# Cottam Solar Project

## Statement of Common Ground with Upper Witham Internal Drainage Board Revision A

PINS Ref: EN010133  
Document reference: EX4/C8.3.7\_A  
Infrastructure Planning (Examination Procedure) Rules 2010

### Figure 8.16.2: Landscape and Ecology Mitigation and Enhancement Plan – Cottam 1 North (Sheet 2) Revision A

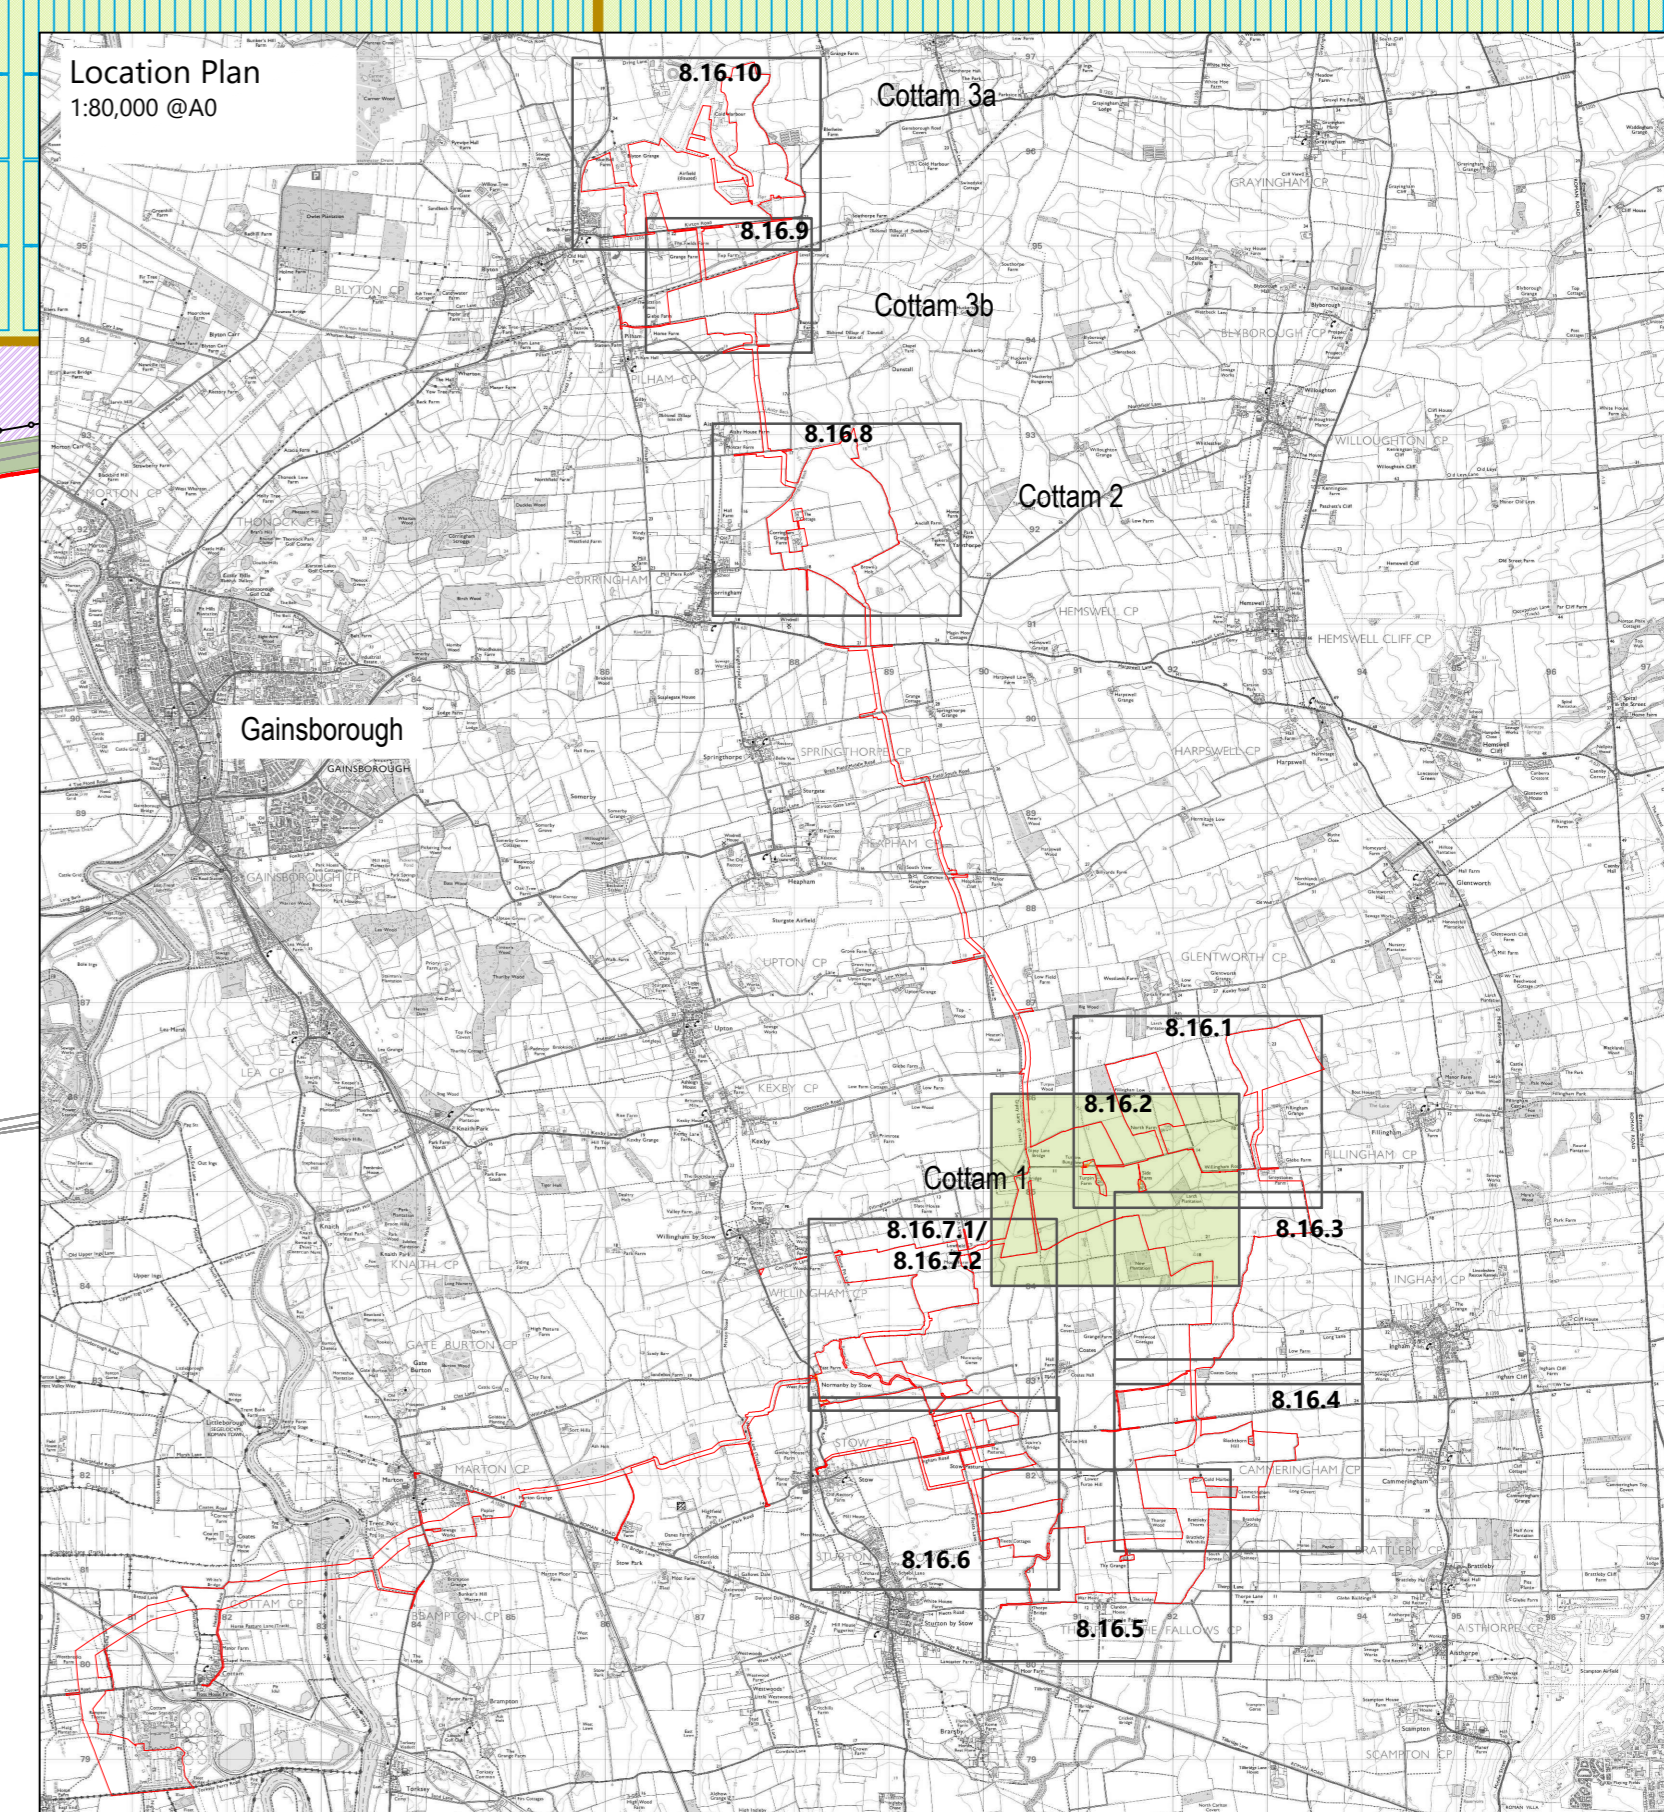
<p>practicable.' EN010133-000461-C7.6 Design and Access Statement_Part 2 of 4 Solar Panels and fencing within 9m of the top of the bank of an Upper Witham IDB watercourse.</p> <p>EN010133-000462-C7.6 Design and Access Statement_Part 3 of 4 Figure 8.16.2</p> <ul style="list-style-type: none"> <li>• IDB watercourses not clearly identified.</li> </ul> <p>0502 - Fillingham South Drain o Fencing, planting and potentially solar panels within the 9m Byelaw distance (from the top of the bank) preventing access for maintenance</p> <p>0500 - East Till o Fencing, planting and potentially solar panels within the 9m Byelaw distance (from the top of the bank) preventing access for maintenance Figure 8.16.3</p> <ul style="list-style-type: none"> <li>• IDB watercourses not clearly identified.</li> </ul> <p>0600 - Cammeringham Drain o Fencing, planting and potentially solar panels within the 9m Byelaw distance (from the top of the bank) preventing access for maintenance Figure 8.16.4</p> <ul style="list-style-type: none"> <li>• IDB watercourses not clearly identified.</li> </ul> <p>0600 - Cammeringham Drain o Fencing, planting and potentially solar panels within the 9m Byelaw distance (from the top of the bank) preventing access for maintenance Figure 8.16.5</p> <ul style="list-style-type: none"> <li>• IDB watercourses not clearly identified.</li> </ul> <p>0700 - Cricket Till o Fencing and potentially solar panels within the 9m Byelaw distance (from the top of the bank) preventing access for maintenance Figure 8.16.7.1 &amp; 2</p> <p>IDB watercourses not clearly identified. • 0500 - East Till o Fencing, planting and potentially solar panels within the 9m Byelaw distance (from the top of the bank) preventing access for maintenance</p> <p>0400 - Padmoor Drain o No comments</p>

<p><u>Hydrology</u> <u>HY-03</u></p>	<p>Identification of Watercourses</p>	<p><i>"Figure 8.16.2: IDB watercourses not clearly identified.</i></p> <p><i>0502 - Fillingham South Drain. Fencing, planting and potentially solar panels within the 9m Byelaw distance (from the top of the bank) preventing access for maintenance</i></p> <p><i>0500 - East Till. Fencing, planting and potentially solar panels within the 9m Byelaw distance (from the top of the bank) preventing access for maintenance.</i></p>	<p>These IDB watercourses and drains have been considered throughout the layouts with a 9m offset as has been possible and as shown on <b>Landscape and Ecology Mitigation and Enhancement Plans (Figures 8.16.1 to 8.16.10) [APP-305 to APP-315]</b>. The Applicant has discussed this matter with the IDB and both parties are in agreement that the scale of the Scheme makes it impossible to provide the</p>

<p><i>Figure 8.16.3: IDB watercourses not clearly identified.</i> 0600 - Cammeringham Drain. Fencing, planting and potentially solar panels within the 9m Byelaw distance (from the top of the bank) preventing access for maintenance.</p> <p><i>Figure 8.16.4: IDB watercourses not clearly identified.</i> 0600 - Cammeringham Drain. Fencing, planting and potentially solar panels within the 9m Byelaw distance (from the top of the bank) preventing access for maintenance.</p> <p><i>Figure 8.16.5: IDB watercourses not clearly identified.</i> 0700 - Cricket Till. Fencing and potentially solar panels within the 9m Byelaw distance (from the top of the bank) preventing access for maintenance.</p> <p><i>Figures 8.16.7.1 &amp; 2: IDB watercourses not clearly identified.</i> 0500 - East Till. Fencing, planting and potentially solar panels within the 9m Byelaw distance (from the top of the bank) preventing access for maintenance.</p> <p>0400 - Padmoor Drain. No comments.</p> <p>0106 - Throops Drain. Fencing, planting and potentially solar panels within the 9m Byelaw distance (from the top of the bank) preventing access for maintenance.</p> <p><i>Figure 8.16.6: IDB watercourses not clearly identified.</i> 0106 - Throops Drain. Fencing, planting and potentially solar panels within the 9m Byelaw distance (from the top of the bank) preventing access for maintenance.</p>	<p>full information regarding detailed design at this stage.</p> <p>The Applicant notes that the drawings are based on the currently available data and mapping and in some cases the 'top of bank' is not defined. It notes that further survey work will be required to establish the 'top of bank' which will in turn give the 9m offset and required clear working access. The IDB can provide a shape file to confirm the locations during the detailed design stage post DCO consent.</p> <p>The Applicant will then provide a specific plan to the IDB at the detailed design stage (post DCO consent) to give clear details of all 9m offsets to the IDB's maintained watercourses and drains.</p>

Figure 8.16.6: Landscape and Ecology Mitigation and Enhancement Plan – Cottam 1 West (Sheet 1) Revision A

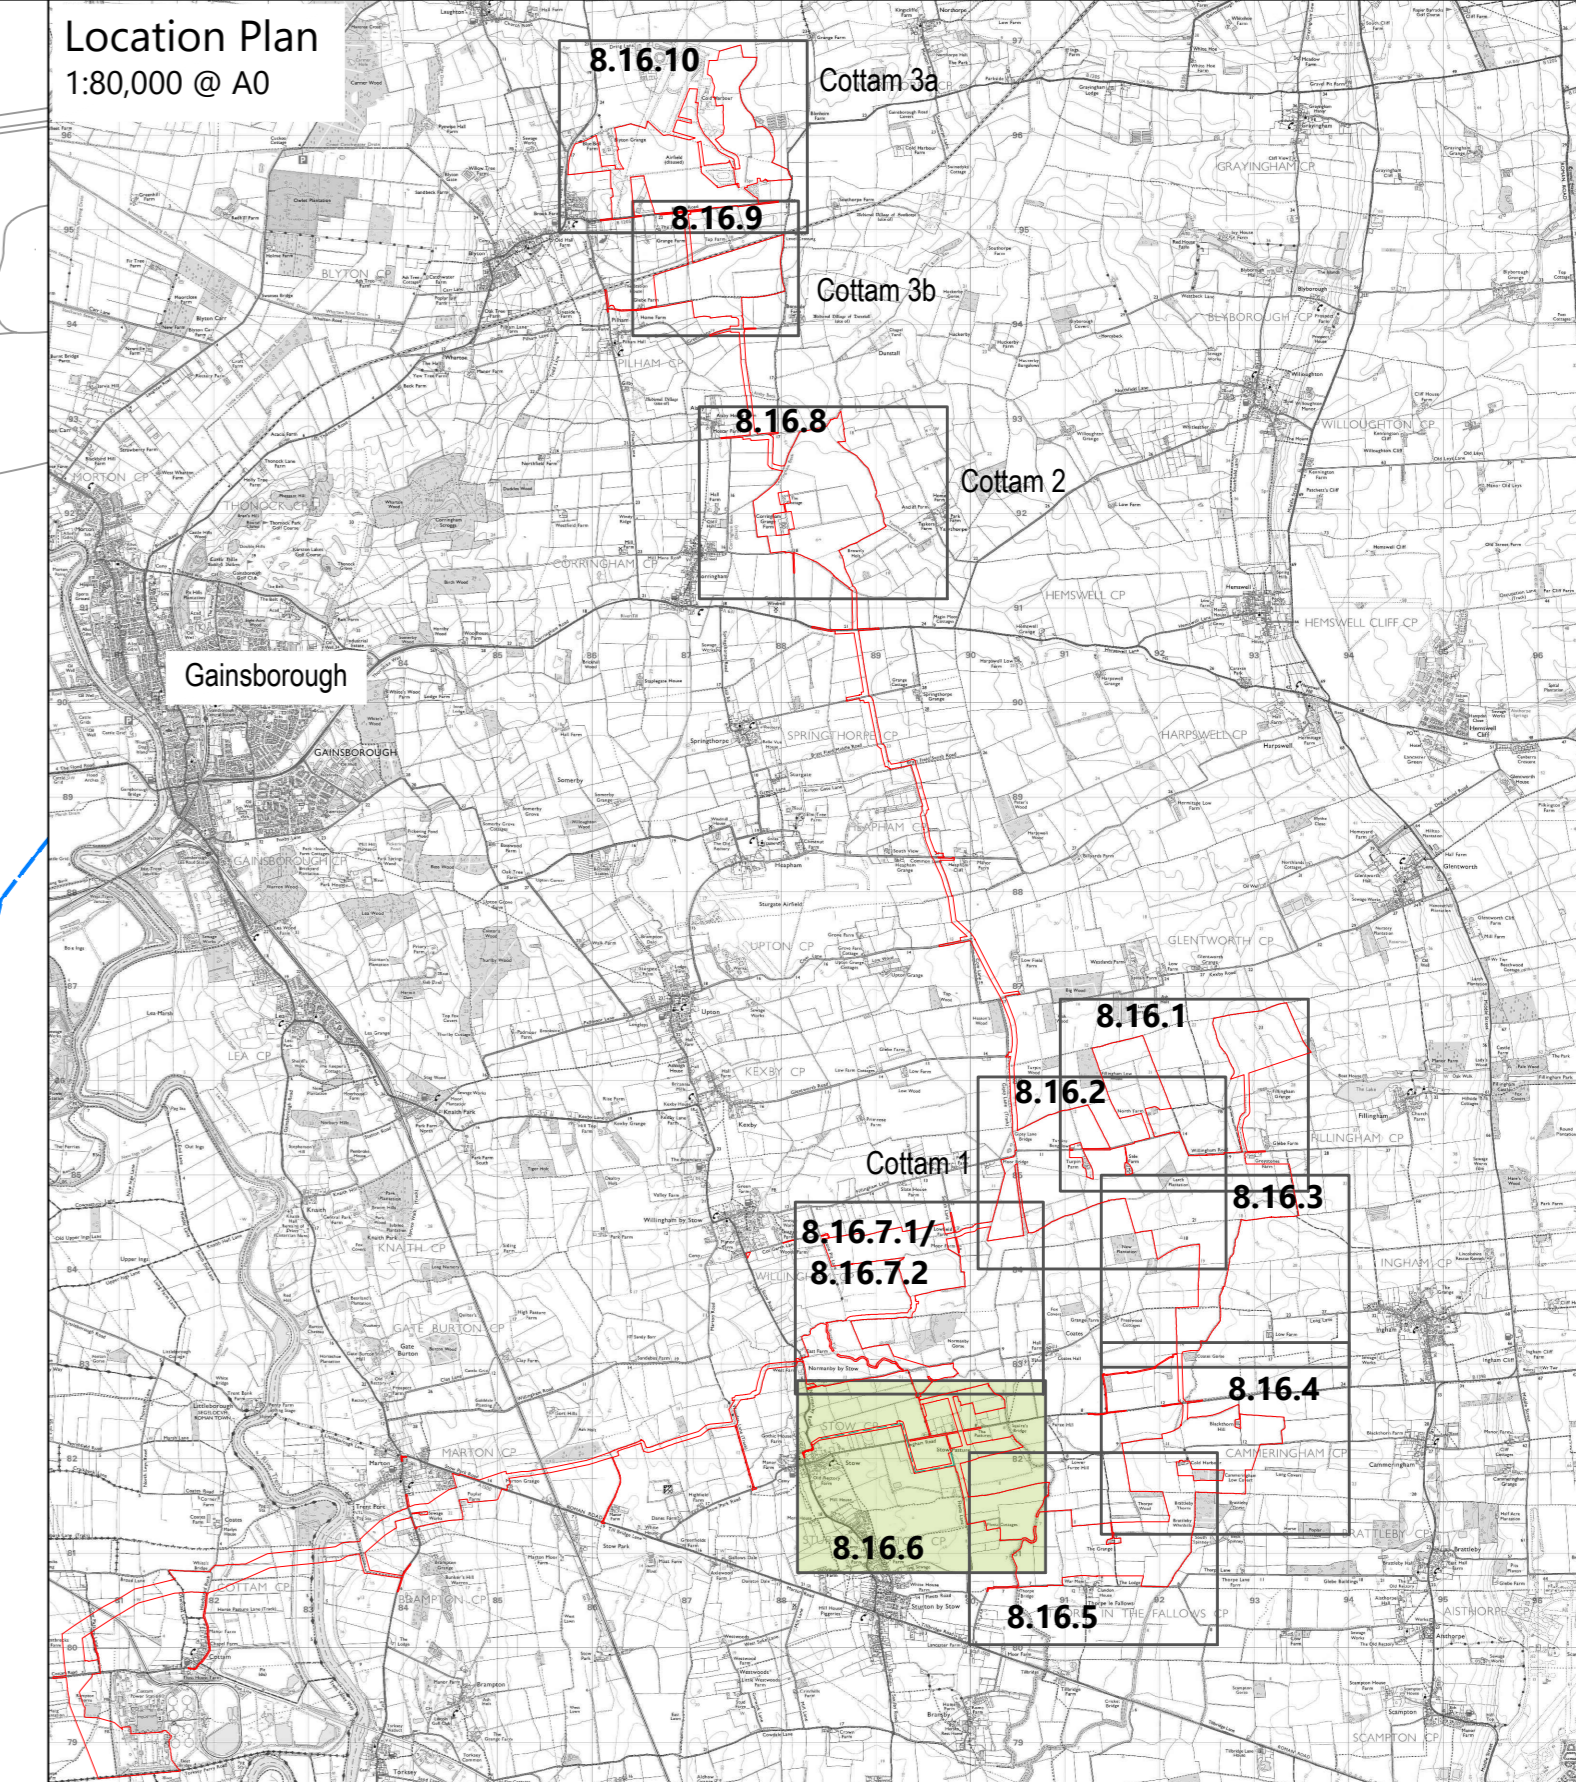
<p>0106 - Throops Drain o Fencing, planting and potentially solar panels within the 9m Byelaw distance (from the top of the bank) preventing access for maintenance Figure 8.16.6</p> <ul style="list-style-type: none"> <li>• IDB watercourses not clearly identified.</li> </ul> <p>0106 - Throops Drain o Fencing, planting and potentially solar panels within the 9m Byelaw distance (from the top of the bank) preventing access for maintenance Only Cottam 1 is within the area relevant to Upper Witham IDB. For Cottam 2 and Cottam 3A/3B Scunthorpe &amp; Gainsborough IDB should be consulted.</p>
--	--	--
